CITY OF PORTLAND, MAINE

SITE PLAN REVIEW

Lot 10 Hutchins Drive
Address of Proposed Site

RE: Stroudwater Estates Lot 10

**PLAN**  
1" = 20'

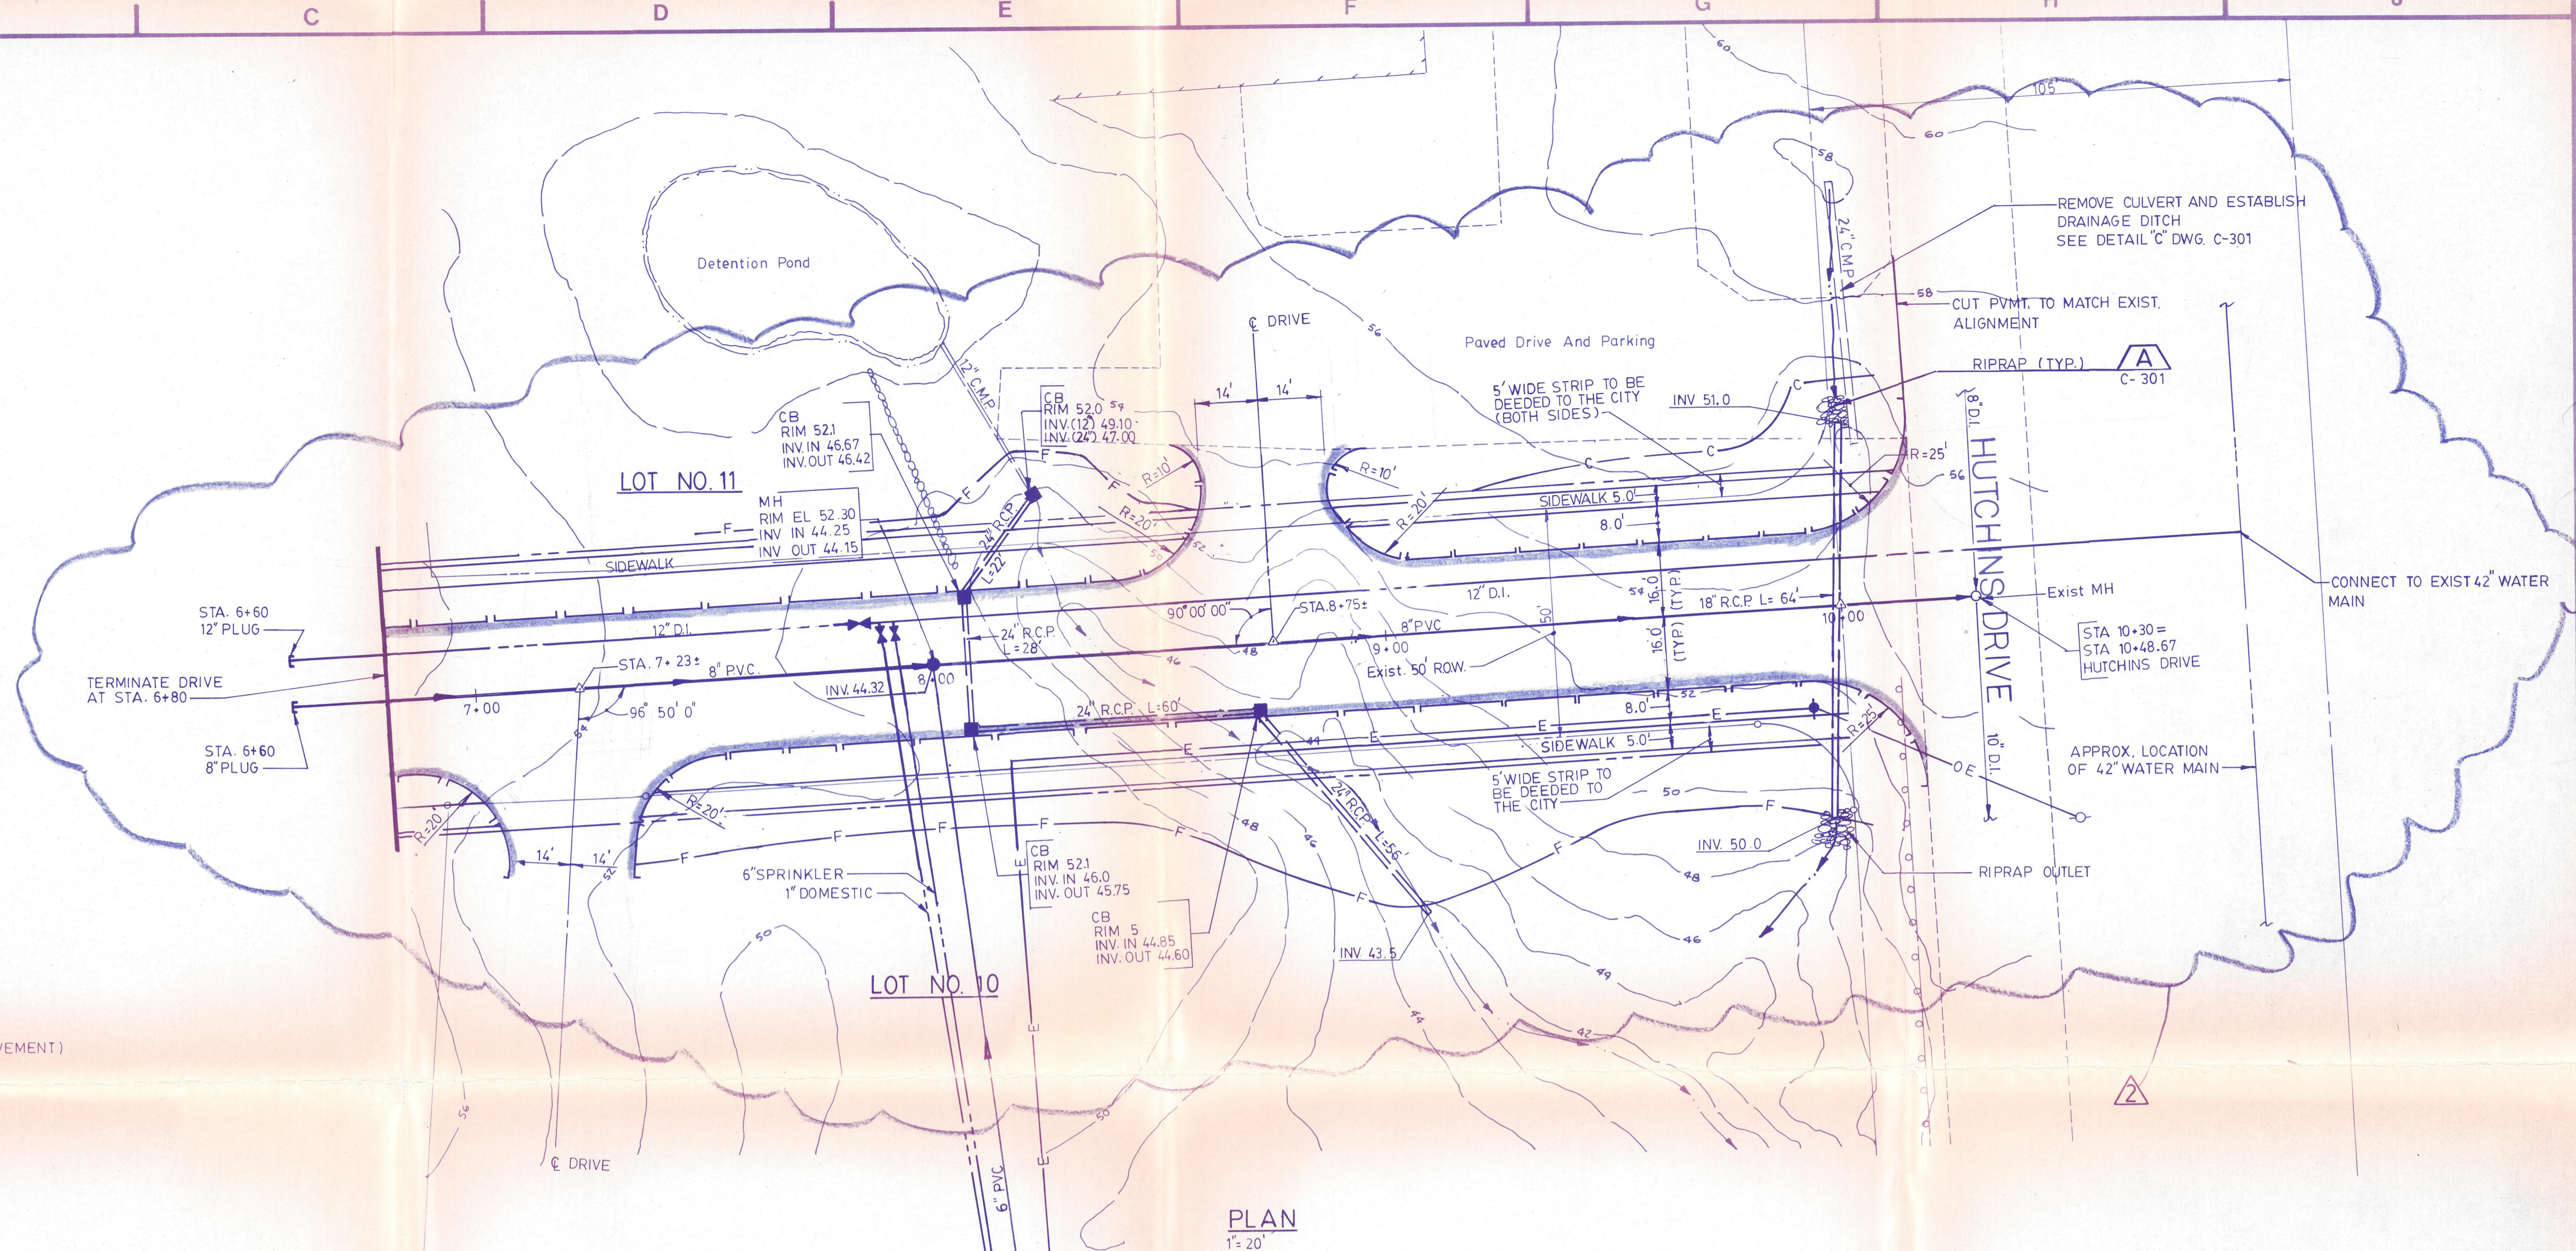
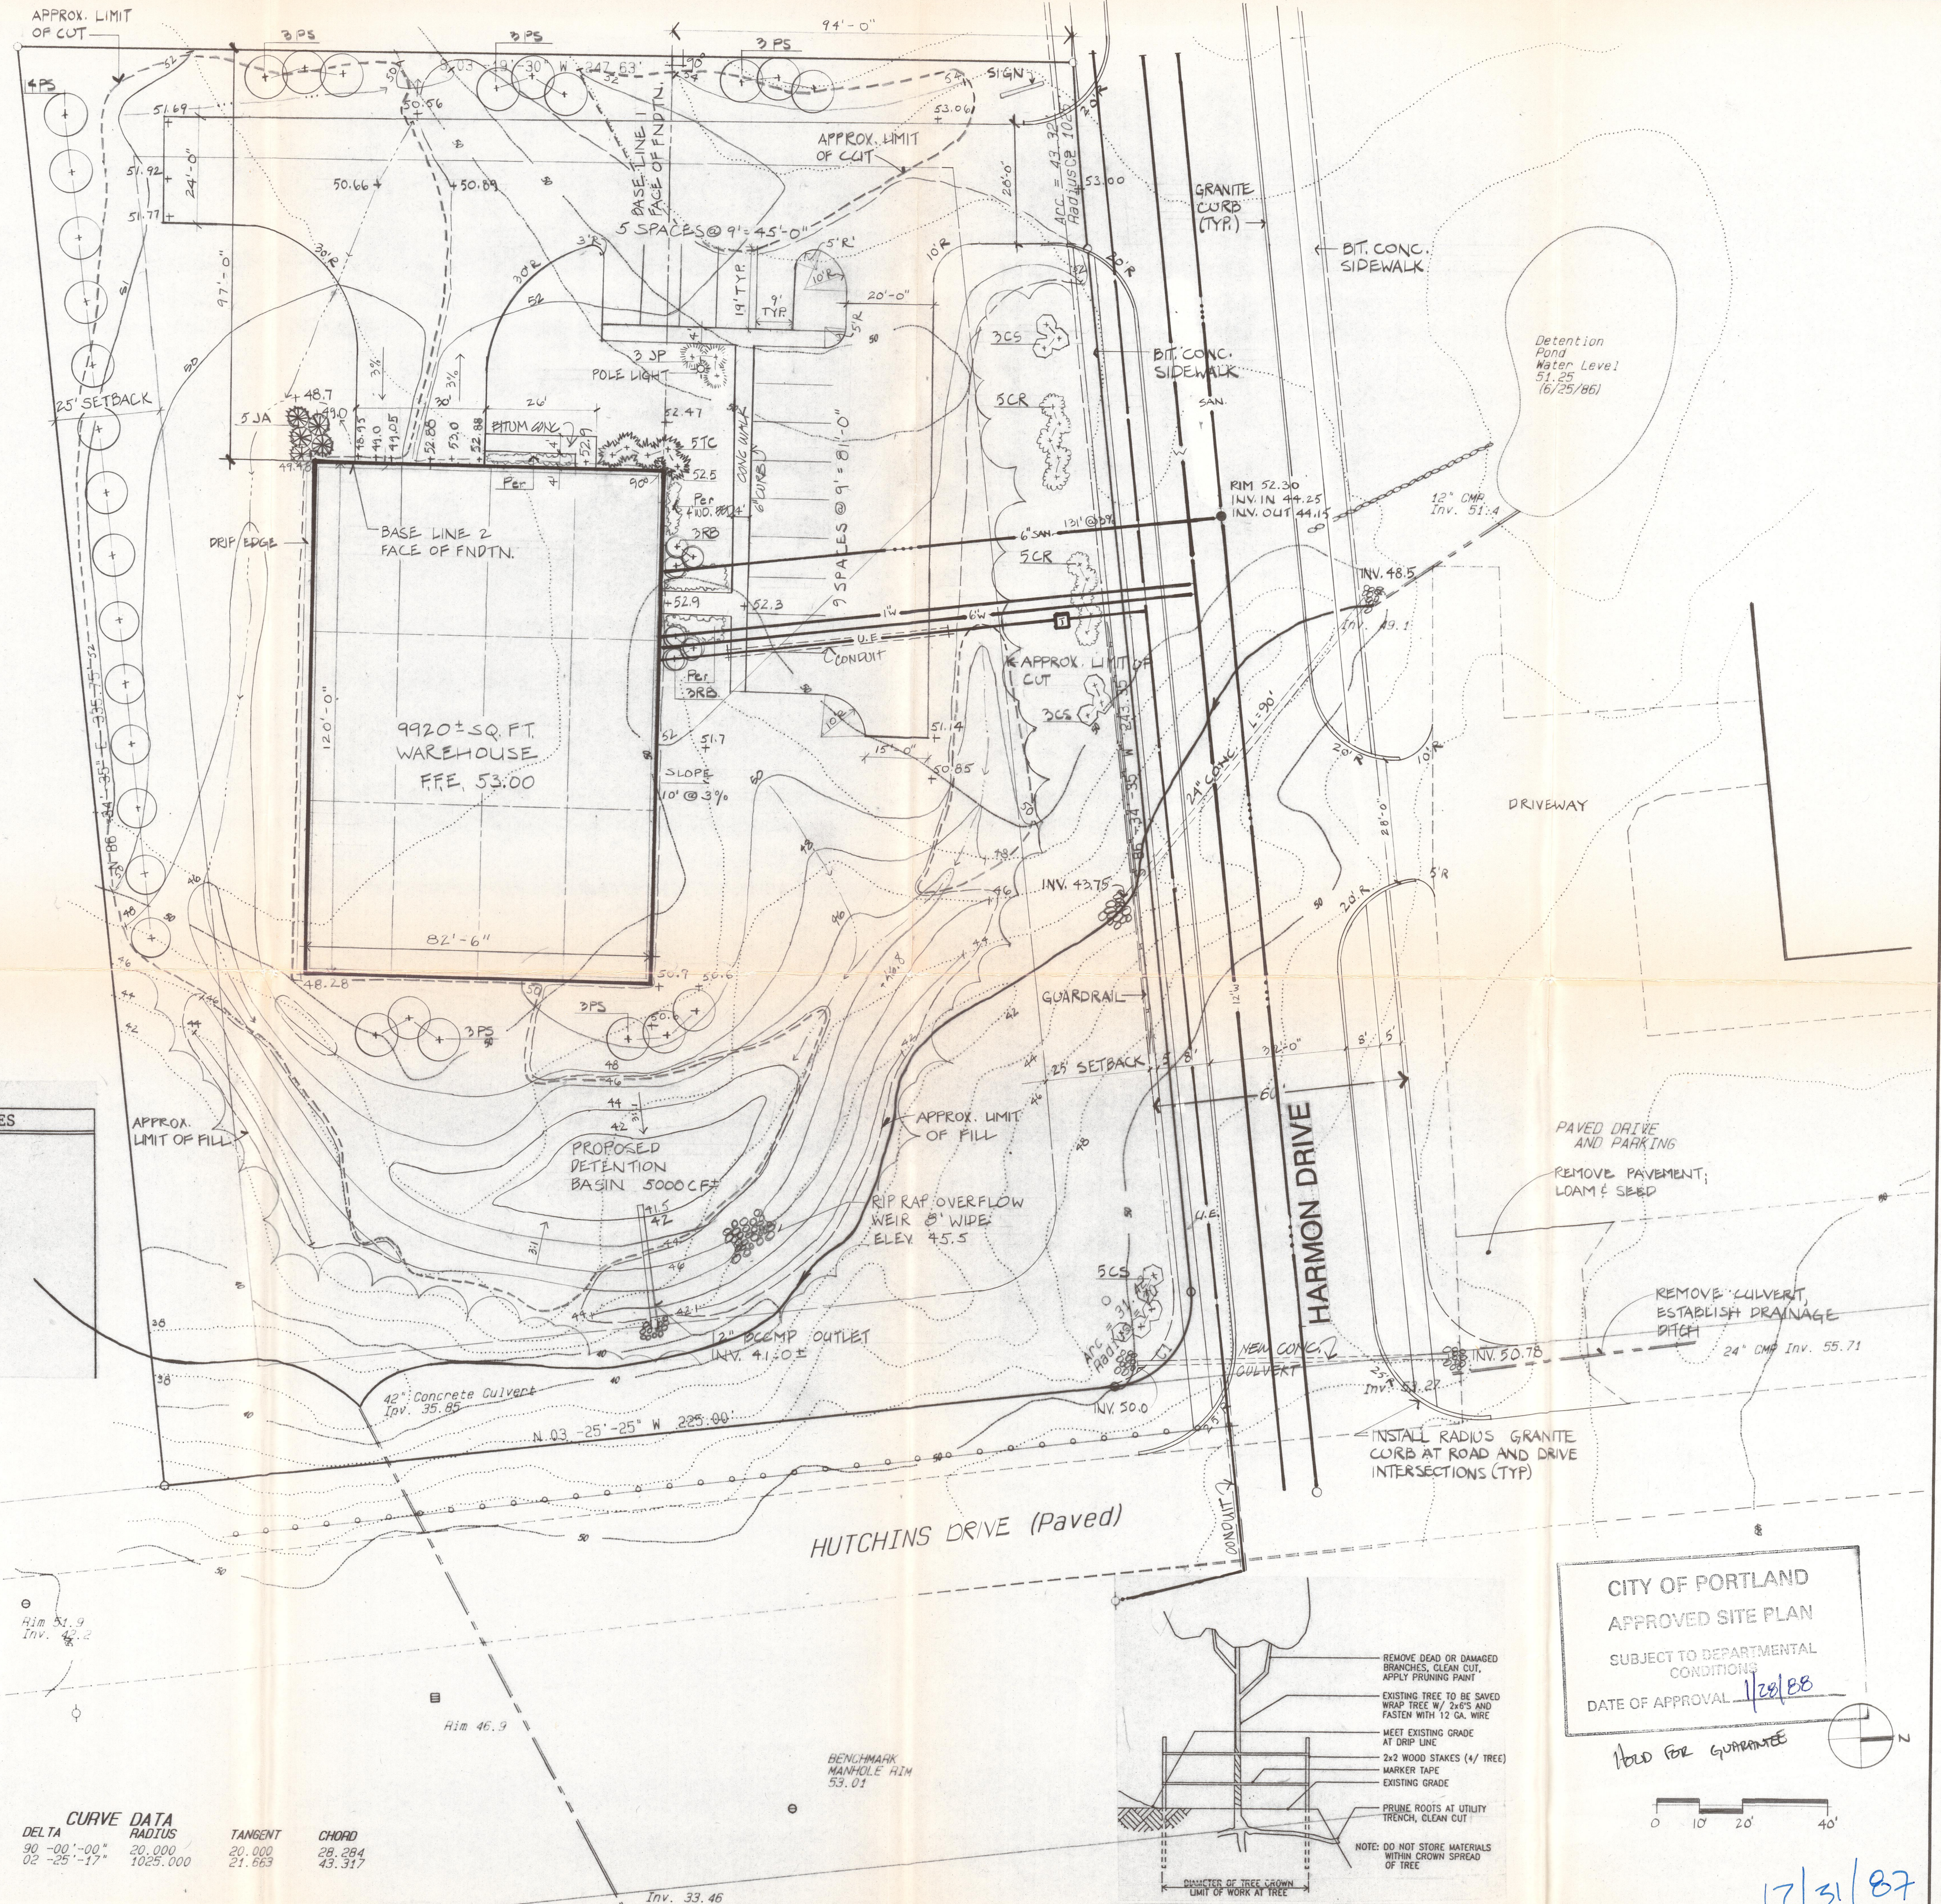
I think it would be appropriate to recommend approval of the design with the condition that the grading be redesigned adjacent to the northeast corner of the detention basin. We suggest this for two reasons:

1. The proposed 24" culvert shows about 14" of cover where it crosses the drainage swale. We recommend that there be at least two feet of cover here to protect the pipe.
2. The top of the berm on the easterly side of the detention basin is shown at EL 45.0. This would place the bottom of the emergency spillway at EL 44.5. However, the new outlet control structure will have to have a water surface elevation of 44.8 if it is to work properly when a 25 year storm occurs. We recommend raising the berm to EL 46.0 with an emergency spillway EL 45.5. This will require some regrading but all the hydraulics should work out.

I phoned Shawn this morning and he agreed that doing the regrading to get additional cover over the pipe and raising the berm to EL 46.0 was not a big problem. If all goes well, you should be getting a revised plan very soon. Under the circumstances, I think there would be no problem with approval with conditions. I'll keep the file until we get the new grading drawing and after that is checked I'll return everything to your office.
